# **CITY OF PORTLAND, MAINE**

## **HISTORIC PRESERVATION BOARD**

Re: 14 Marshall Street – Dormer Addition  
CBL: 063 C022

On November 1, 2017, Portland's Historic Preservation Board voted 6-0 to approve your application to construct a shed dormer on the north slope of the roof at 14 Marshall Street. Approval is based on the specifications and information provided for the public hearing held on November 1, 2017, and is subject to the following conditions:

SHEET:
A-04

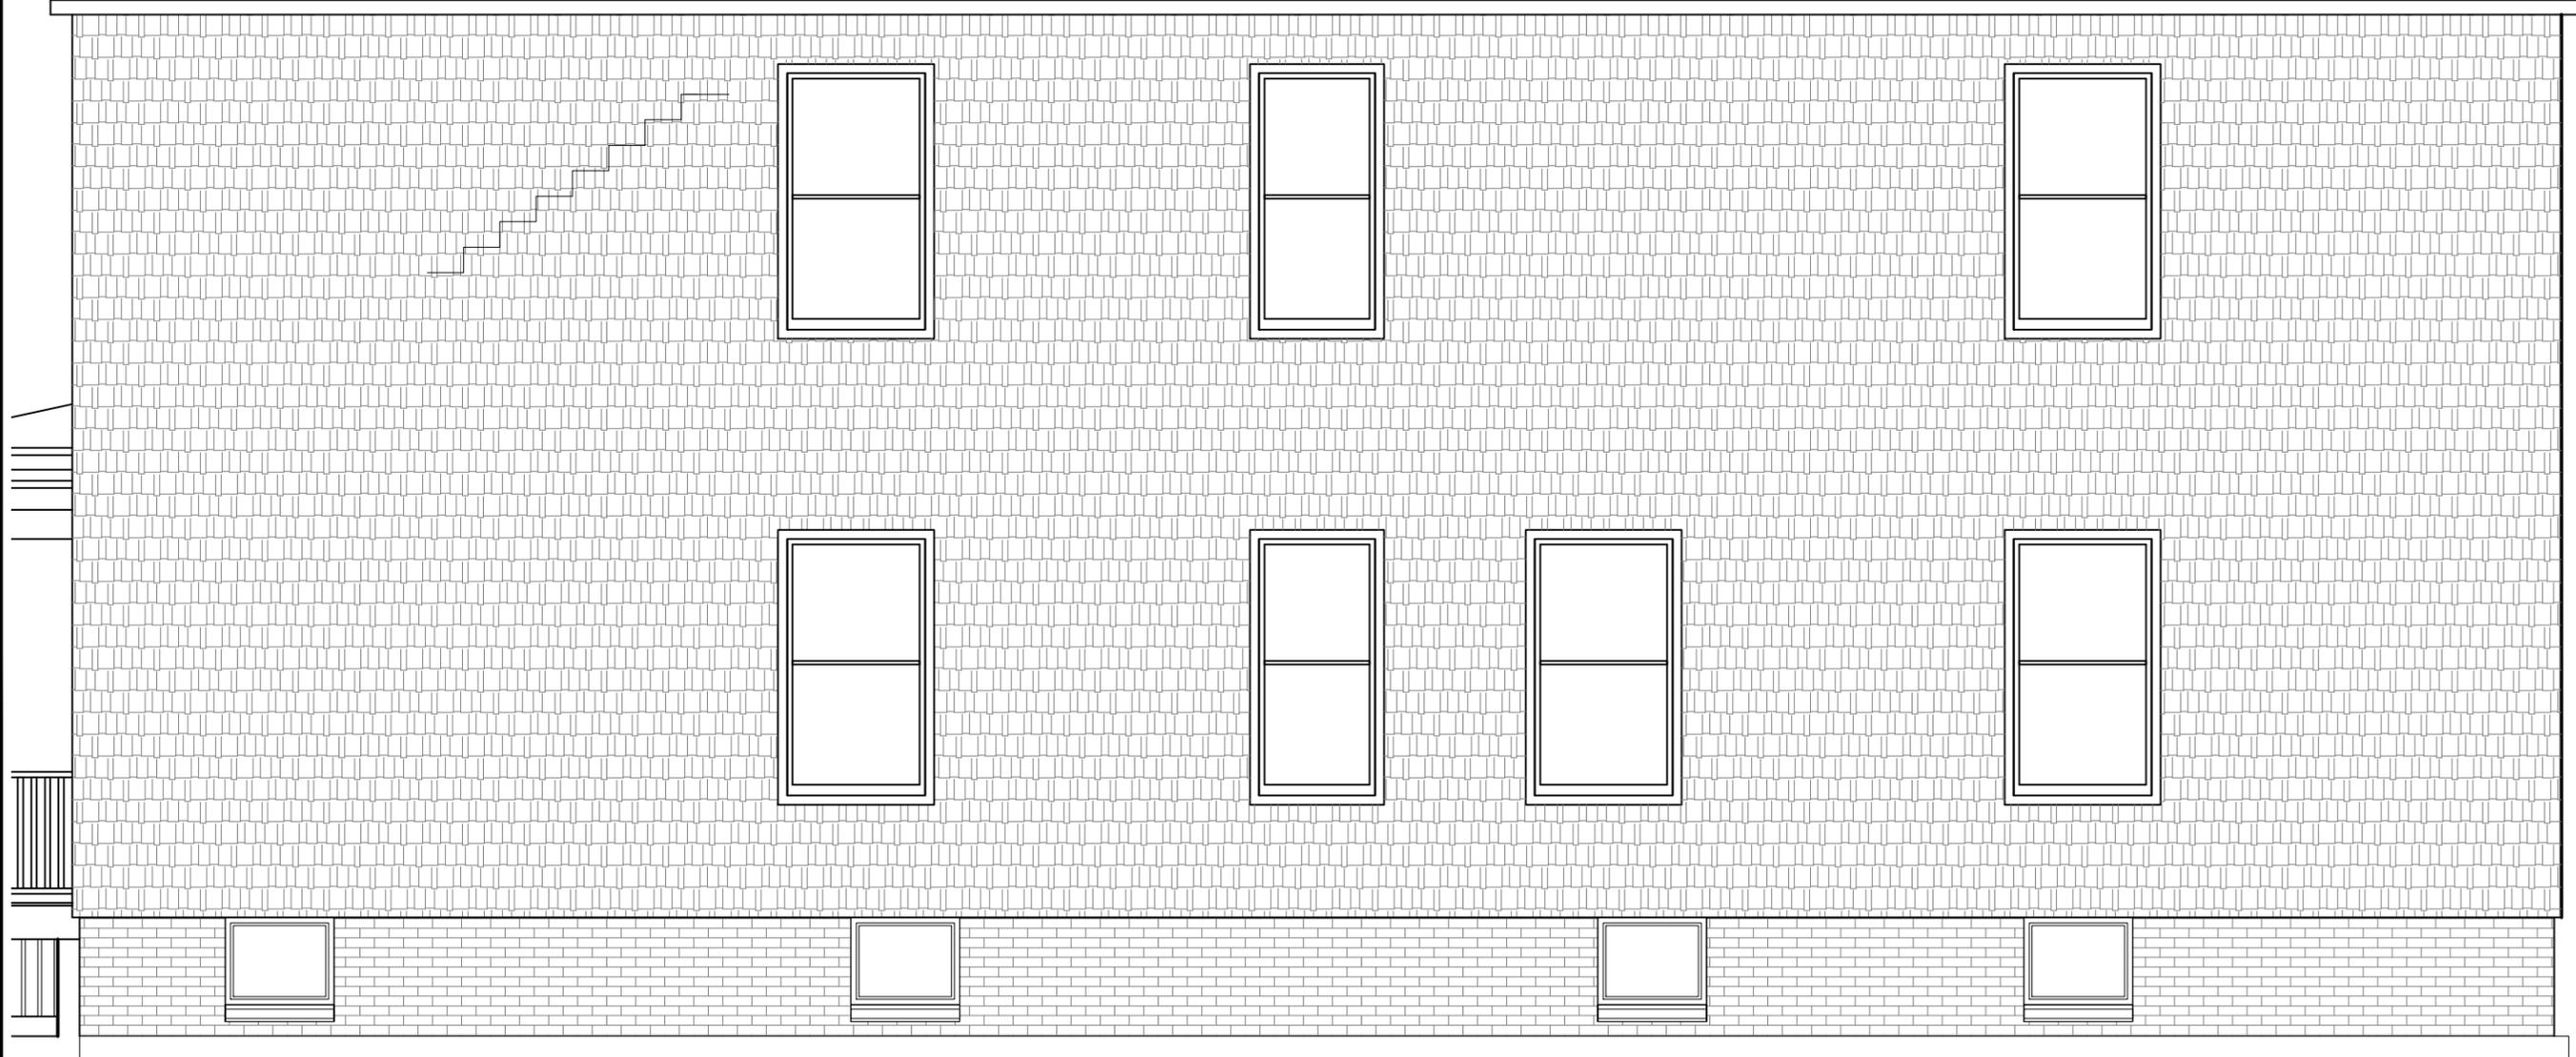
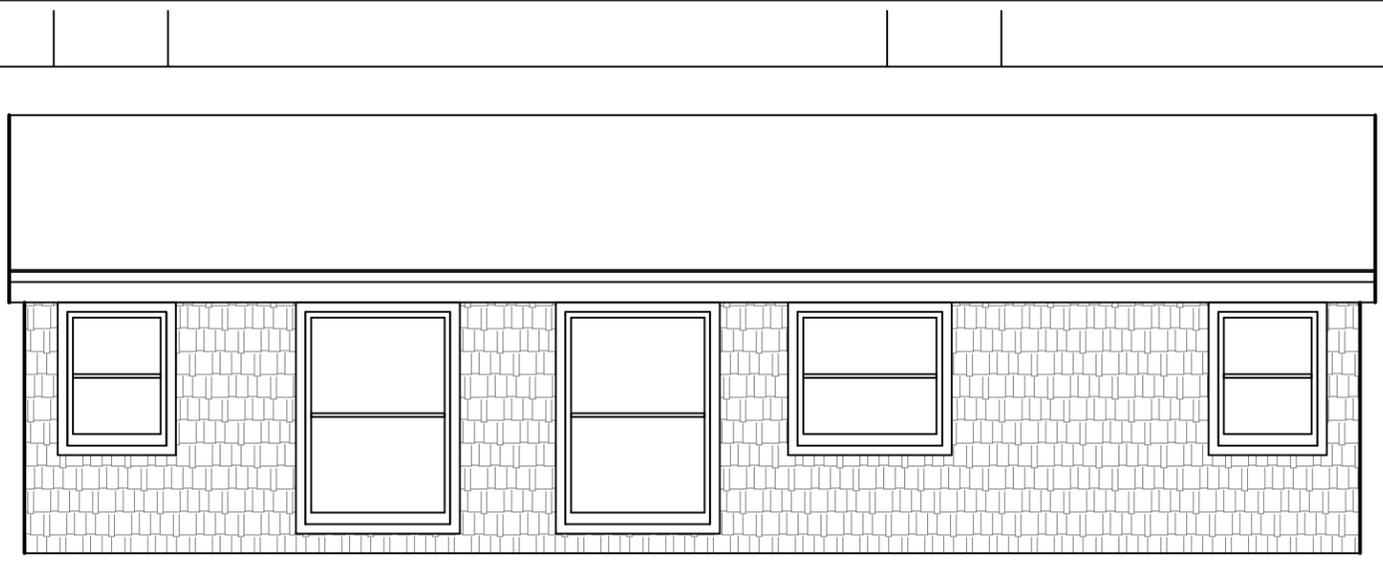
- The kitchen window is to be the same width as the bathroom window, to reduce the number of different window sizes in the dormer and to be consistent with the more vertically oriented proportions of other windows

All improvements shall be carried out as shown in the plans and specifications submitted to HP staff, except as specified above. In addition, please submit to staff a revised elevation and plan (including window revision and trim details) for review and approval, as well as a sample of the siding material.
